WEST SUSSEX COUNTY COUNCIL CONSULTATION

TO:	Arun District Council FAO: Michael Eastham
FROM:	WSCC - Highway Authority: Tim Townsend
DATE:	2 nd December 2020
LOCATION:	Land South of Ford Lane east of North End Road Yapton Arundel BN18 0DS
SUBJECT:	Y/131/20/DOC Approval of details reserved by condition imposed under ref APP/C3810/W/17/3170059 (Y/80/16/OUT) relating to Condition Nos 7 - means of access/egress onto Ford Lane, 8 - retention & improvement of Public Rights of Way 357, 358, 359 & new cycle & pedestrian routes, 9 - Stage 1 Road Safety Audit, 12 - Travel Plan and 17 - Phase 1 Habitat Survey
DATE OF SITE VISIT:	n/a
RECOMMENDATION:	More Information Required
S106 CONTRIBUTION TOTAL:	n/a

This is the WSCC County Highway Authority (CHA) response to the above planning application for approval of details reserved by condition imposed under ref APP/C3810/W/17/3170059 (Y/80/16/OUT) relating to Condition Nos 7 - means of access/egress onto Ford Lane, 8 - retention & improvement of Public Rights of Way 357, 358, 359 & new cycle & pedestrian routes, 9 - Stage 1 Road Safety Audit, 12 - Travel Plan and 17 - Phase 1 Habitat Survey.

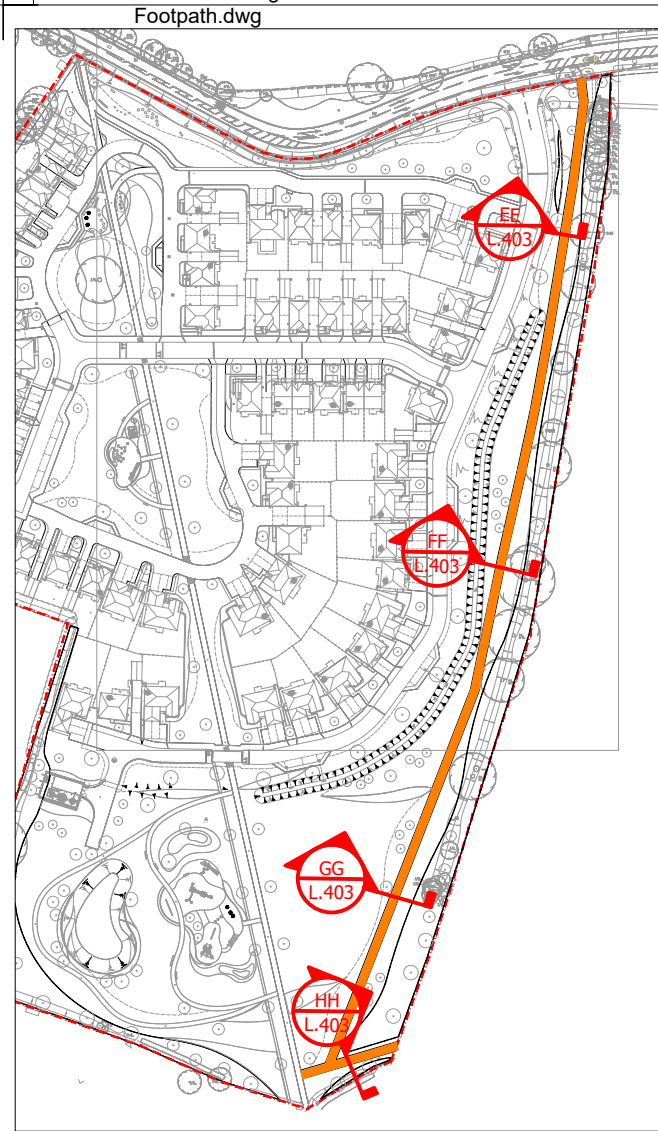
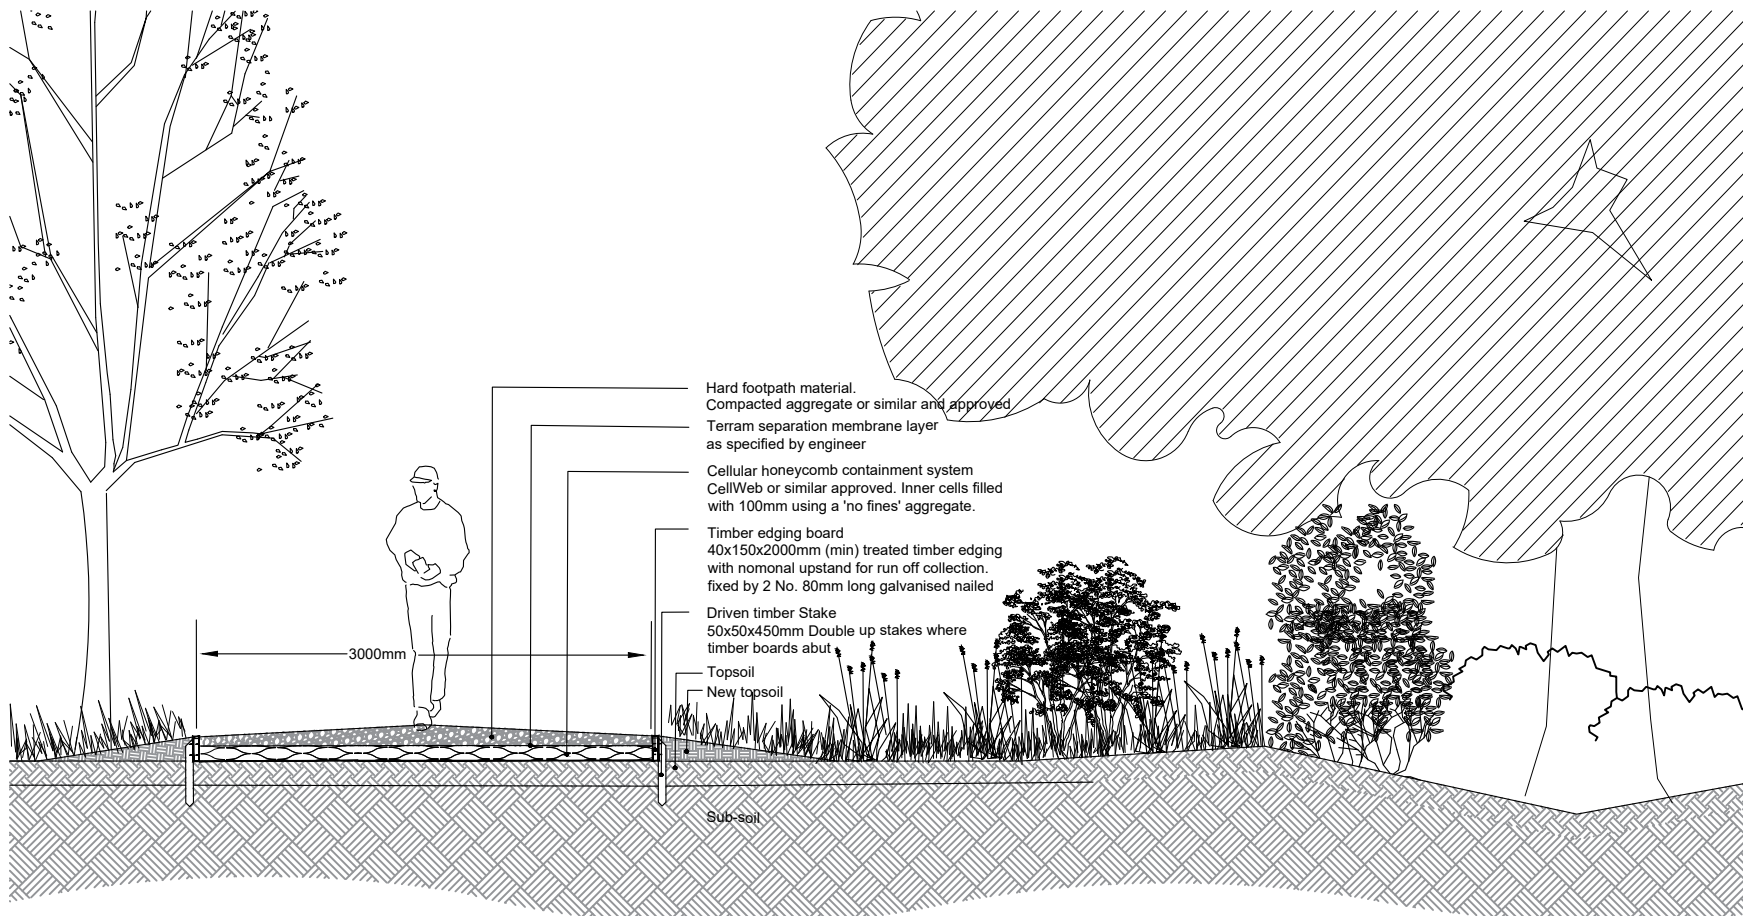
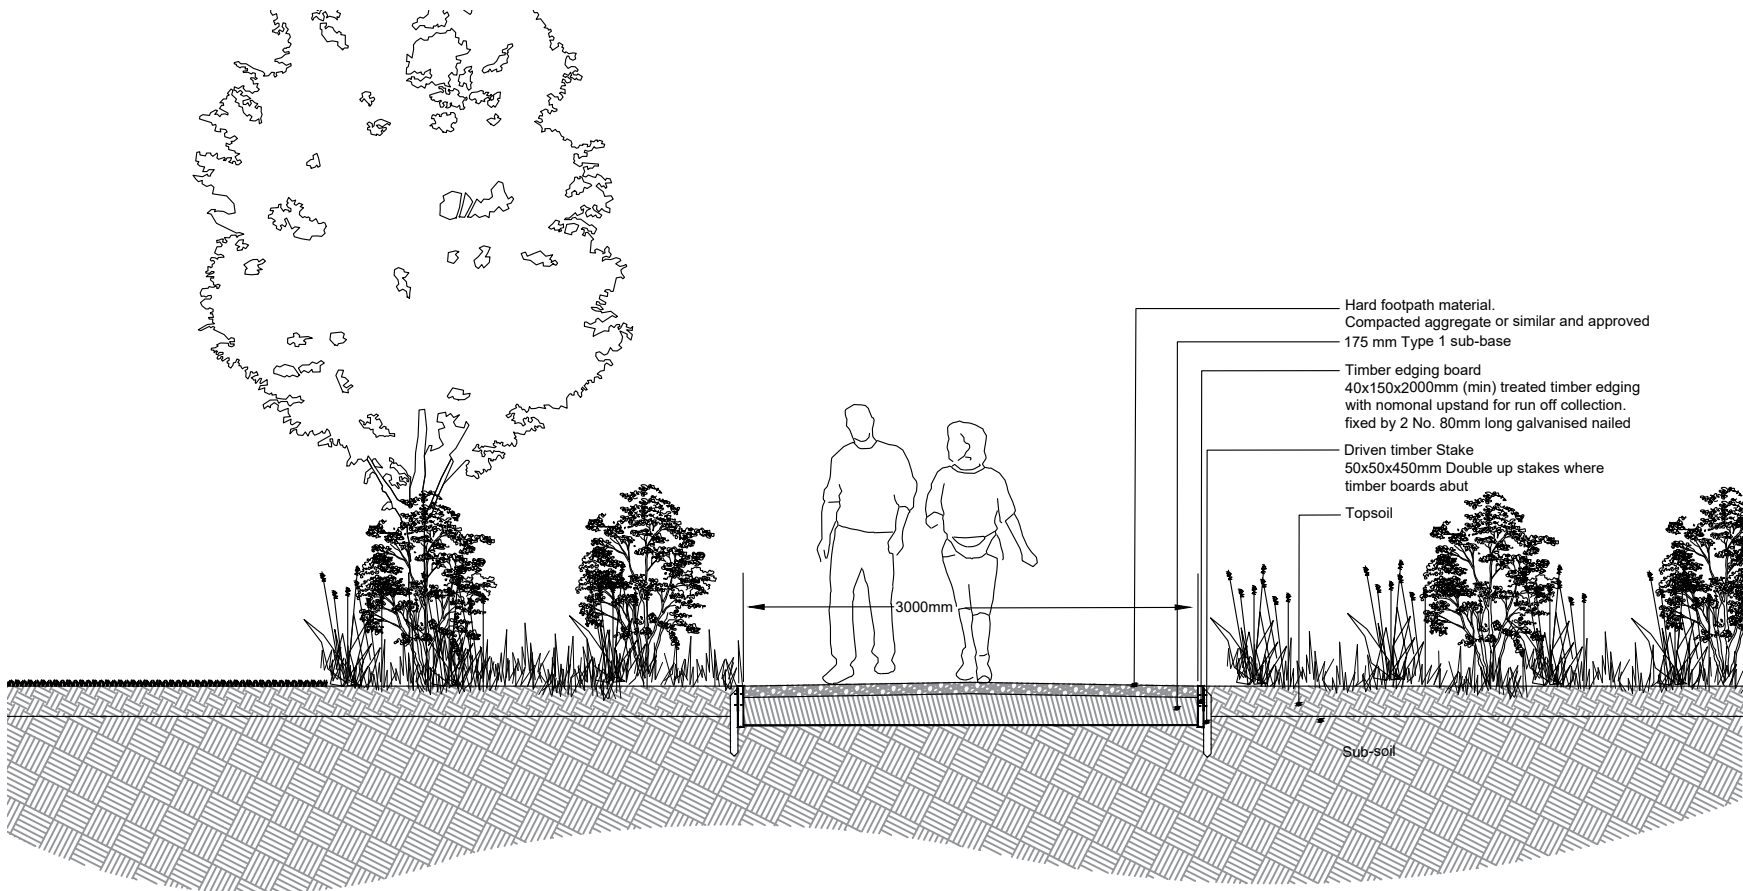
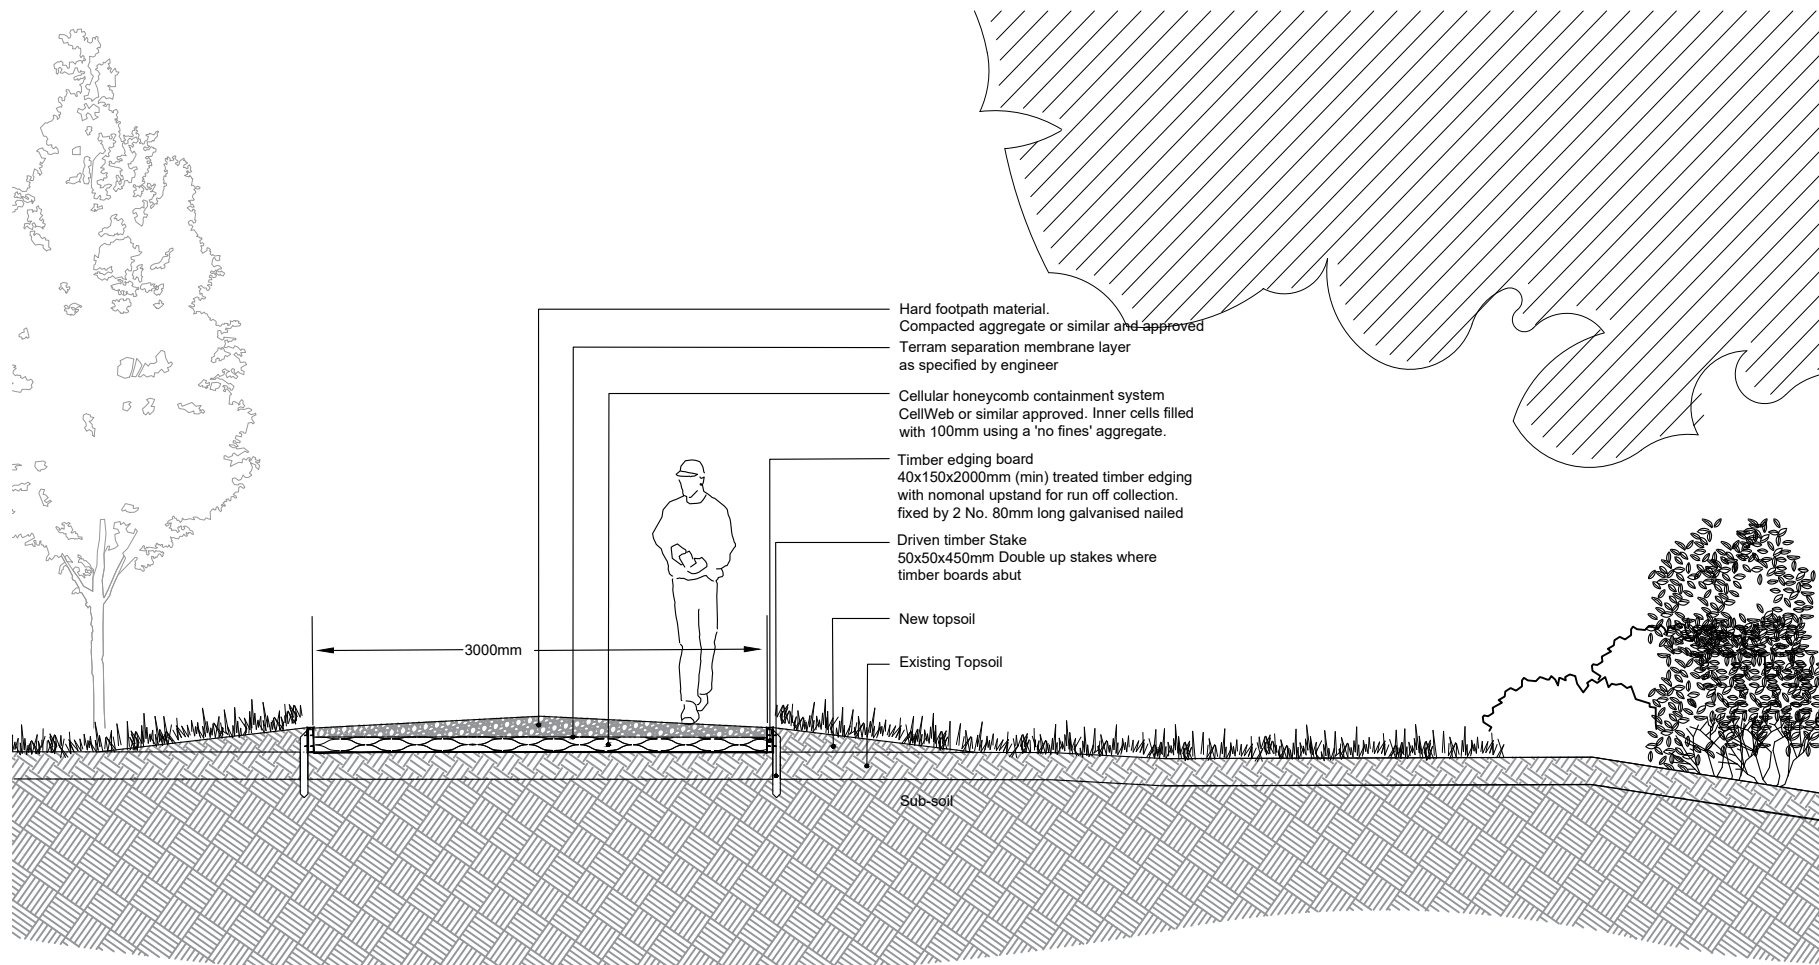
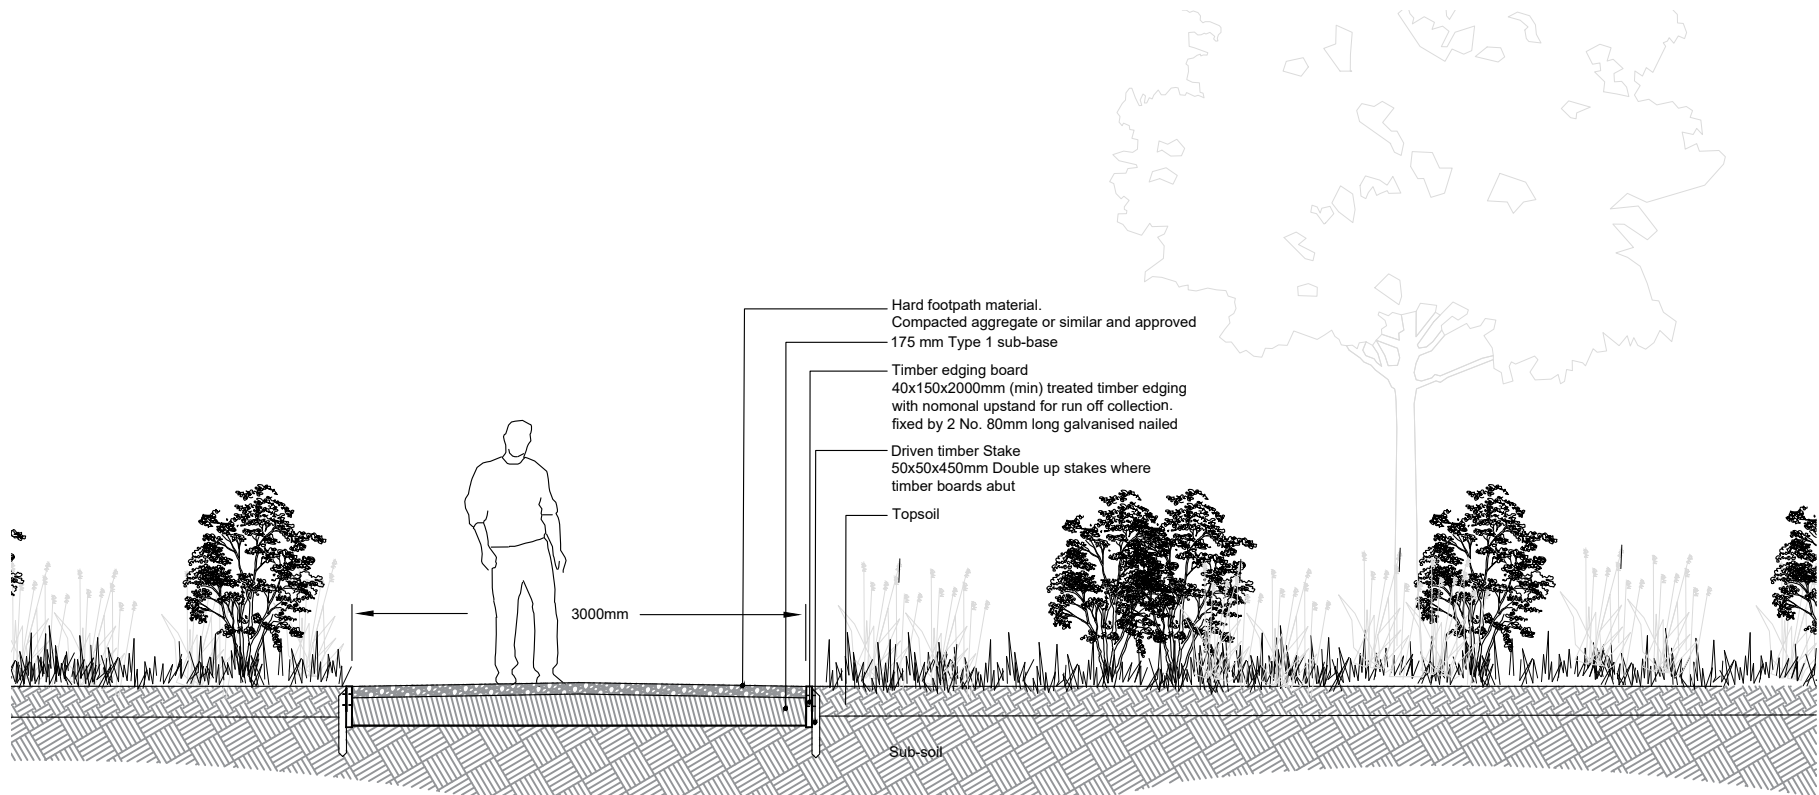
shared foot and cycle use. From observation of the latest drawings, this has not been shown fully as 357 appears to measure 2.0m (it should measure a minimum of 3.0m wide for shared-use), whereas both 358 and 359 are shown measuring 3.0m wide. Since the outline consent, the County Council has been looking at ways to improve access by non-motorised users across the County. This extends to other non-motorised users too and it has been mentioned that access by other users such as equestrians is of interest in the area. Bridleway status for all these paths would legally permit those on foot, cycle and horse to use the paths, albeit recognising that the paths would need to be upgraded, including connections in-and-out of the site. Any path upgrades to permit access over-and-above Public Footpath status would require appropriate Orders to be approved. WSCC PRoW team will be able to advise further.

Movement Plan

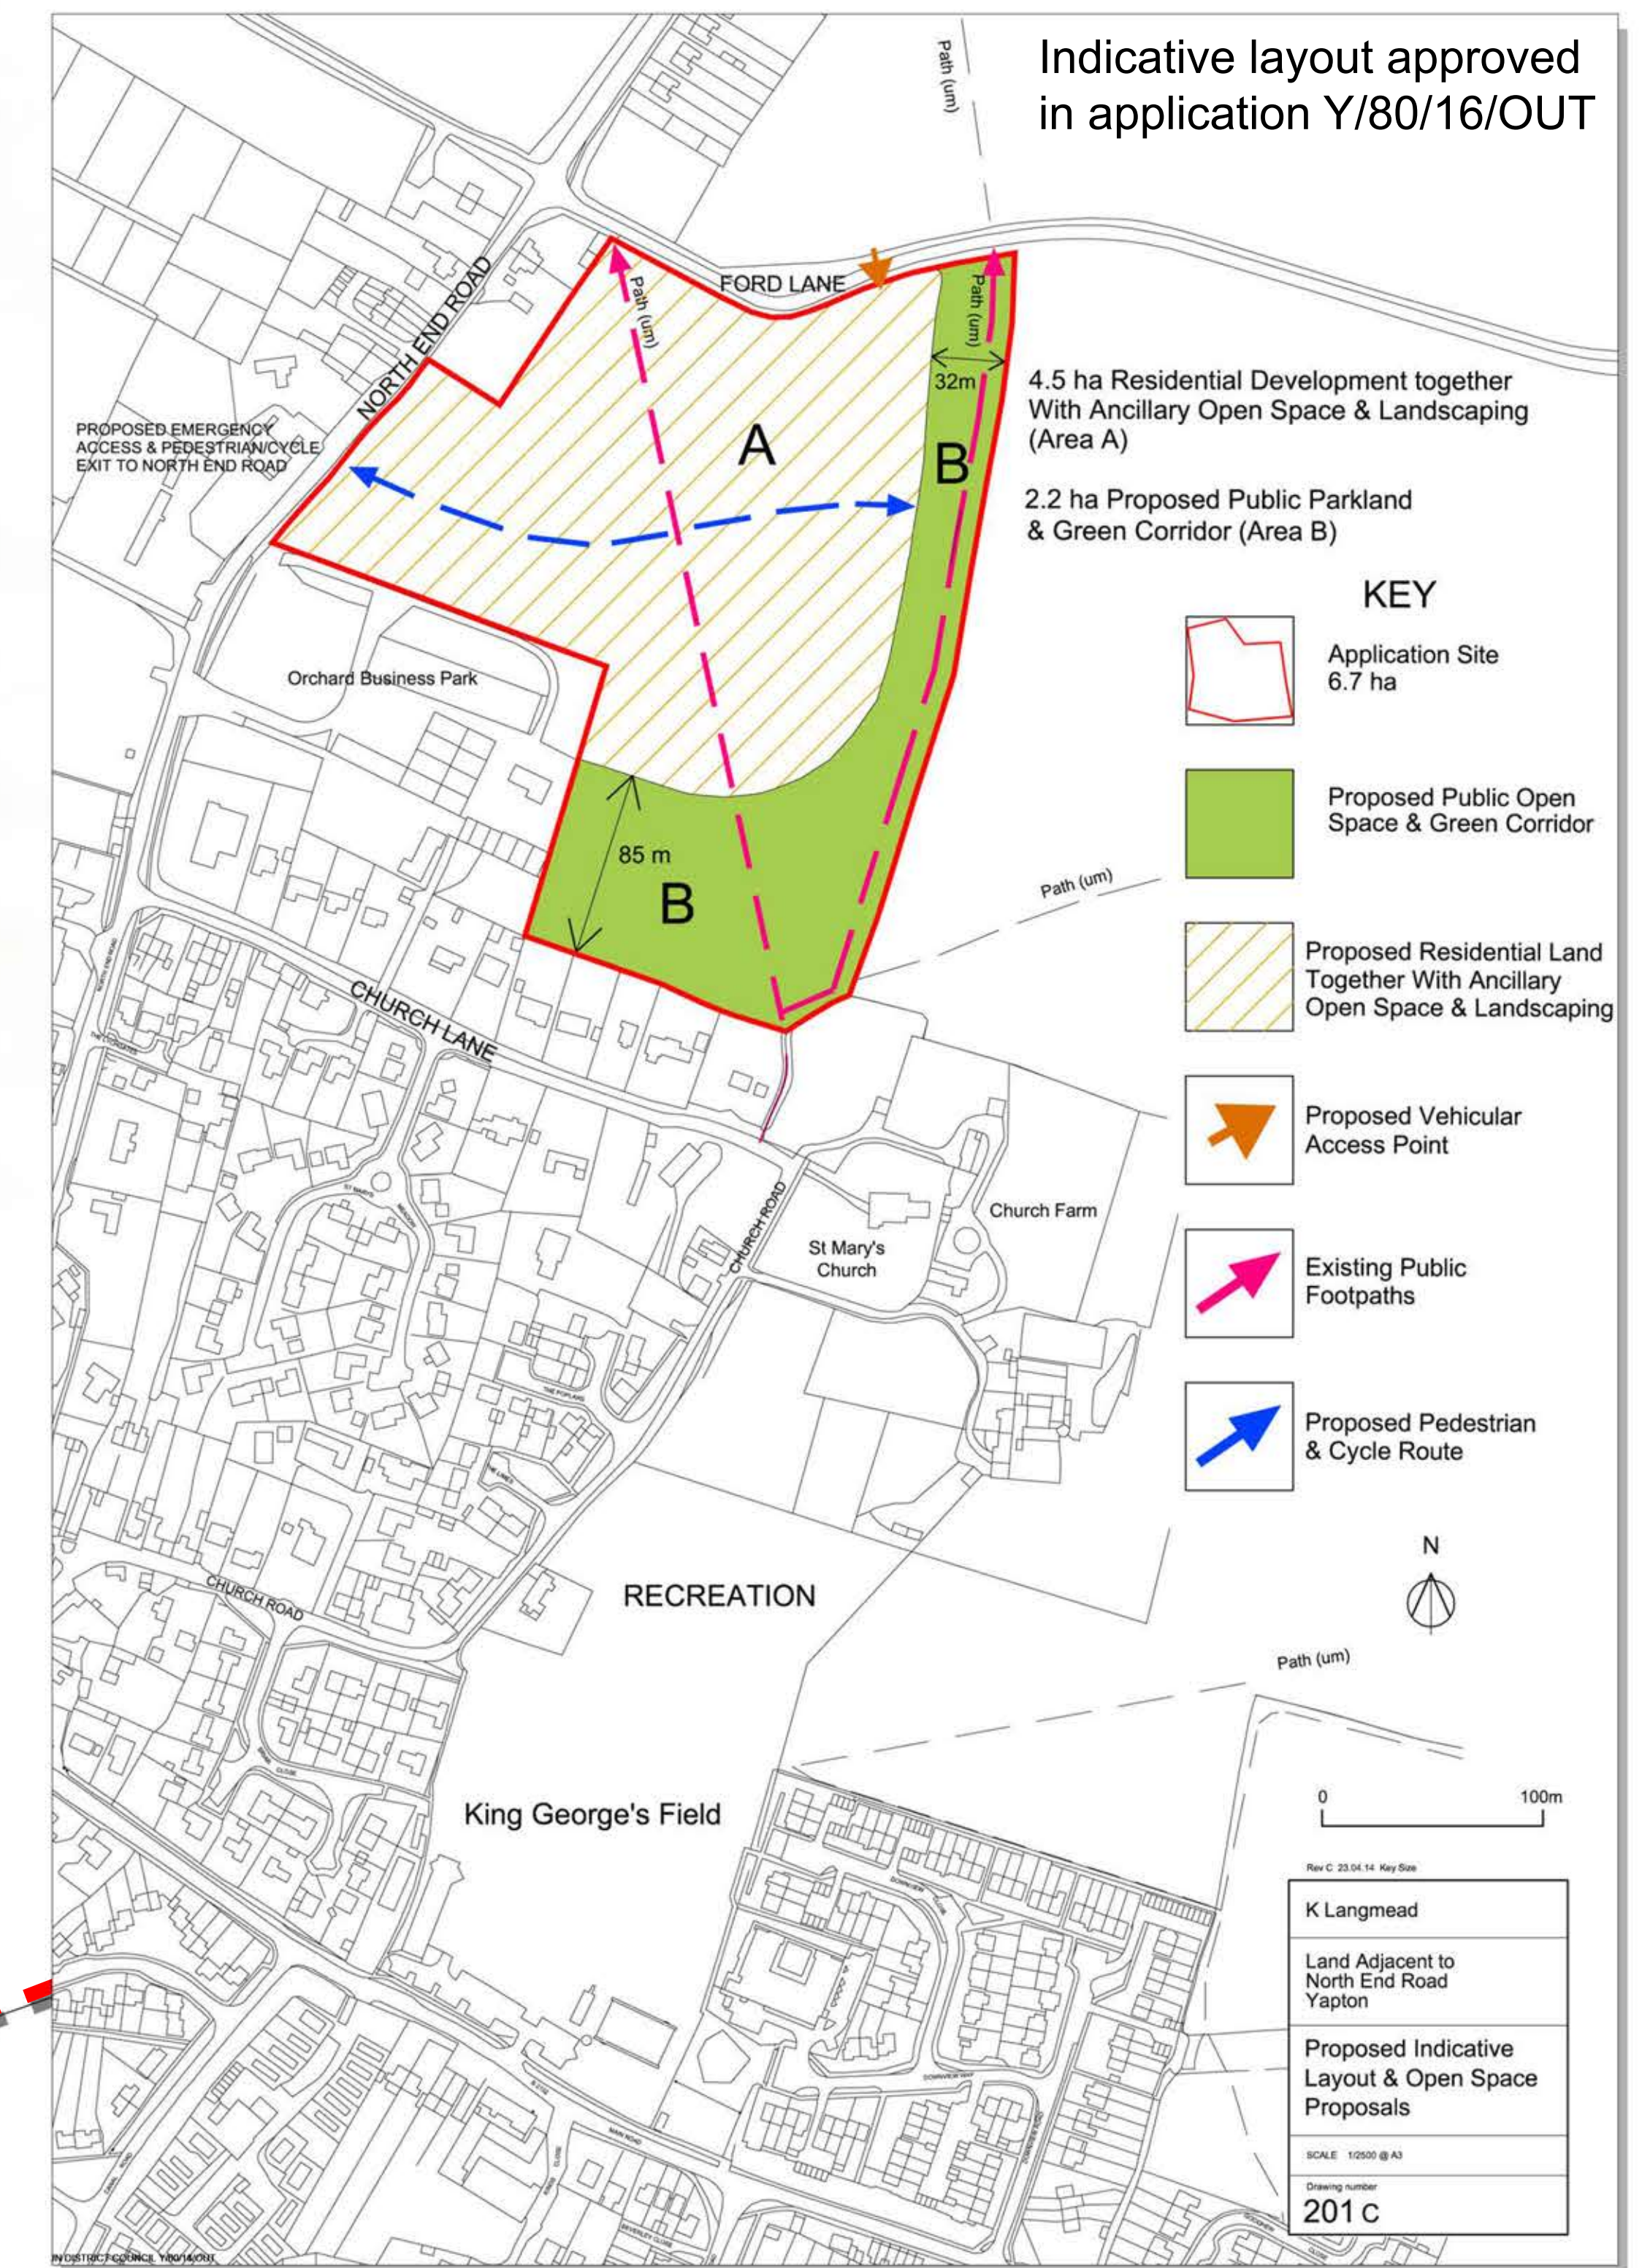
With regard to other paths within the site, a recreational area appears to be shown in the south-western corner of the site. This too should be looked at with a view to providing shared-use paths for a choice of users – those on-foot and cycle at the very least although this would not be something the County Council would adopt.

Finally, the cycle connection onto North End Road narrows to 2.0m when it enters the site. This should be shown a 3.0m wide.
